Kirklees HDM Interim comments

2021/92206 - K3-49/7 - Land off Woodhead Road, Brockholes

Erection of 137 homes with open space, landscaping and associated infrastructure.

15/02/2022

D:\ONEDRIVE\ATTP\18001 BROCK HOLES\DRAWINGS\18001_SPA_001_REV C.DWG

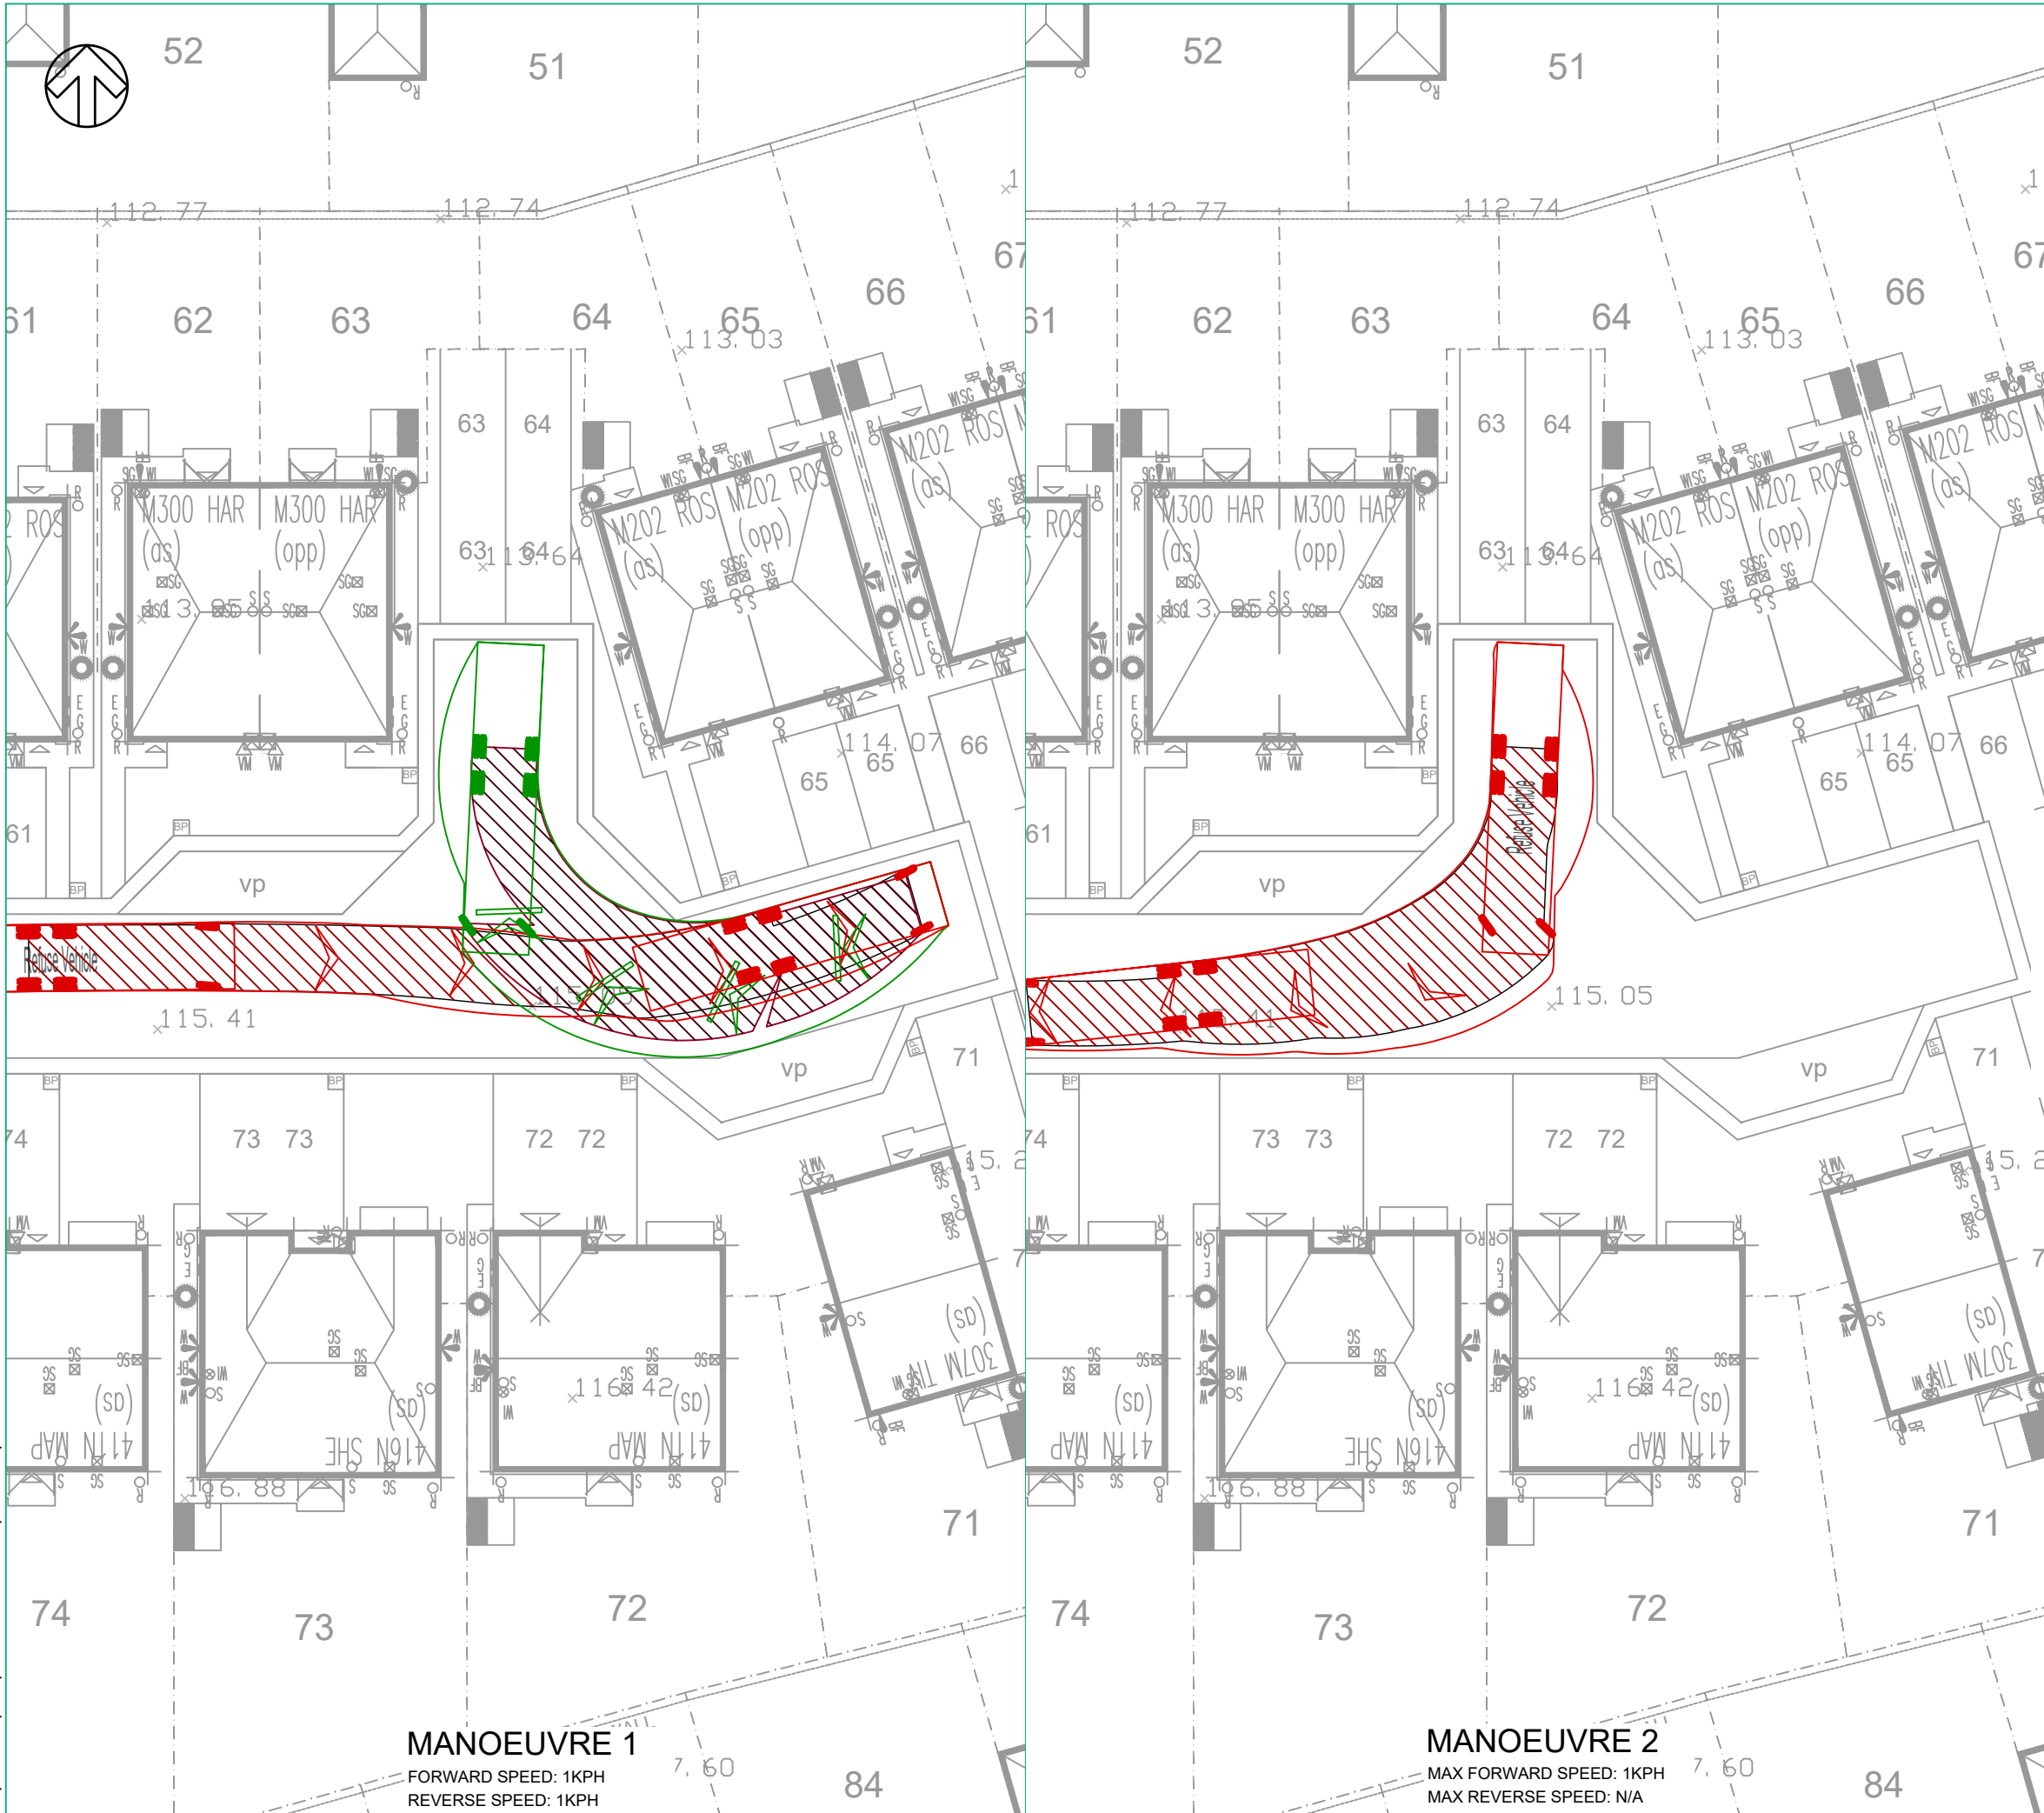
- Swept Path Analysis has been provided in the updated Transport Assessment, which includes two cars passing within the site, and also showing the Councils Design Refuse Vehicle. However, the information is unclear, with all of the refuse vehicle tracking movements included on a single diagram, making the information illegible. Notwithstanding the difficulty in interpreting the SPA information, it is clear that the SPA has not been undertaken in accordance with Council standards that do not permit the use of stationary steering, as this results in wheel scrub and damage to the highway. The SPA also confirms that a number of the turning heads are inadequate based on the current SPA (using stationary steering) showing kerb overrunning, conflict with highway boundaries and conflict with visitor parking bays. Therefore, updated SPA is required without the use of stationary steering, overrunning of kerbs and with adequate clearance from other highway features, with the turning heads enlarged to suit. Specific issues relating to the SPA are confirmed in the following bullet points.

- Whilst the SPA is unclear, it appears that the inbound refuse vehicle movements at the main site access cross the centre line on the site access minor arm. Therefore, should vehicles be queuing to exit the site, these would block the inbound refuse vehicle. This would create a significant safety risk for southbound traffic on Woodhead Road who may then collide with the waiting refuse vehicle. The access should be widened and/or an entry taper provided on the minor arm to ensure that unobstructed access for the refuse vehicle is available at all times.

- On the section of road between Plots 35 and 104, the SPA of the refuse vehicle is shown to use more than the full width of the carriageway to turn, with some overhanging of the footways, which is not acceptable. Should cars be parked near to the junctions at either end of the road, the refuse vehicle would be unable to pass without driving on the footways, which is unacceptable. The road layout should be amended as necessary to ensure that no footway overhanging is required, and additional parking laybys or carriageway widening is provided near to the junctions to reduce the risk of blocking.

- The turning head adjacent to Plots 64 - 71 clearly requires 'lock to lock' stationary steering to function, which is unacceptable. The refuse vehicle is shown overrunning the hard margins and the visitor parking bay, and must be amended.

- The turning head adjacent to No. 11 also clearly requires stationary steering to function and is unacceptable. This could be addressed by extending the turning head and setting back the parking bays for Plot 11.

- The turning head adjacent to Plot 17-19 requires stationary steering to function and is unacceptable, with the refuse vehicle shown impacting on the visitor parking bay. This could be addressed by extending the turning head and setting back the parking bays for Plot 17-19.

- The turning head adjacent to Plot 121-125 requires stationary steering to function and is unacceptable, with the refuse vehicle shown overrunning kerbs, and must be amended.

- As previously stated in the SPA comments, the Council Design Refuse Vehicle must be able to turn into the site access unobstructed by vehicles waiting to exit the minor arm of the junction. Based on the SPA provided, this does not appear possible. Therefore, the access will need to be widened and/or a taper on the minor arm provided.

- As previously stated, revised SPA is required of the Council Design Refuse Vehicle that clearly shows separate vehicle movements, so that it is demonstrated that the refuse vehicle will be able to pass a car at the main site access, at all bends and when passed any on-street parking that may occur, particularly near junctions. Revised SPA is also required at all turning heads to ensure overrunning of kerbs and visitor parking bays does not occur, with any necessary amendments incorporated (See earlier specific points relating to SPA).
